Planning application 2025/93355

Proposed erection of 75 dwellings on land off Woodward Court/Hepworth Lane Mirfield.

I write in connection with the above planning application. I have examined the plans and I know the site well. I wish to object strongly to the development of these houses in this location for the following reasons:

Image 2.3 Proposed Hepworth Lane Site Egress

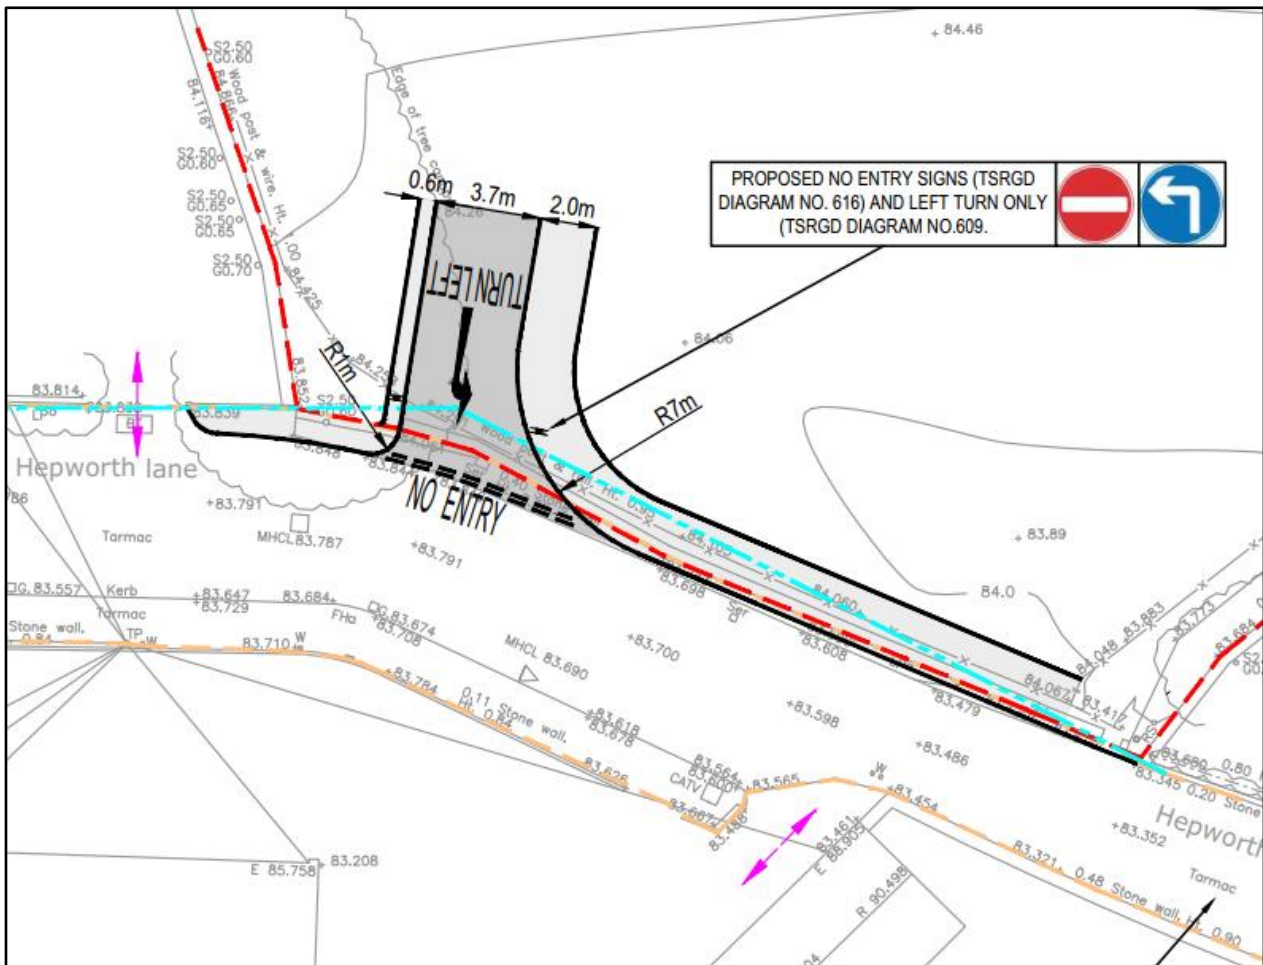
1. **Highway Safety.** The new, one way exit road demands that all traffic turn left causing all the traffic down the very narrow Hepworth Lane which is too narrow for two cars to pass in opposite directions. This will be especially unsafe when the majority of traffic is heading in the opposite direction towards Crossley Fields Schools. This section of Hepworth Lane has NO FOOTPATH so ALL pedestrians will be put at risk walking in the same space as traffic.
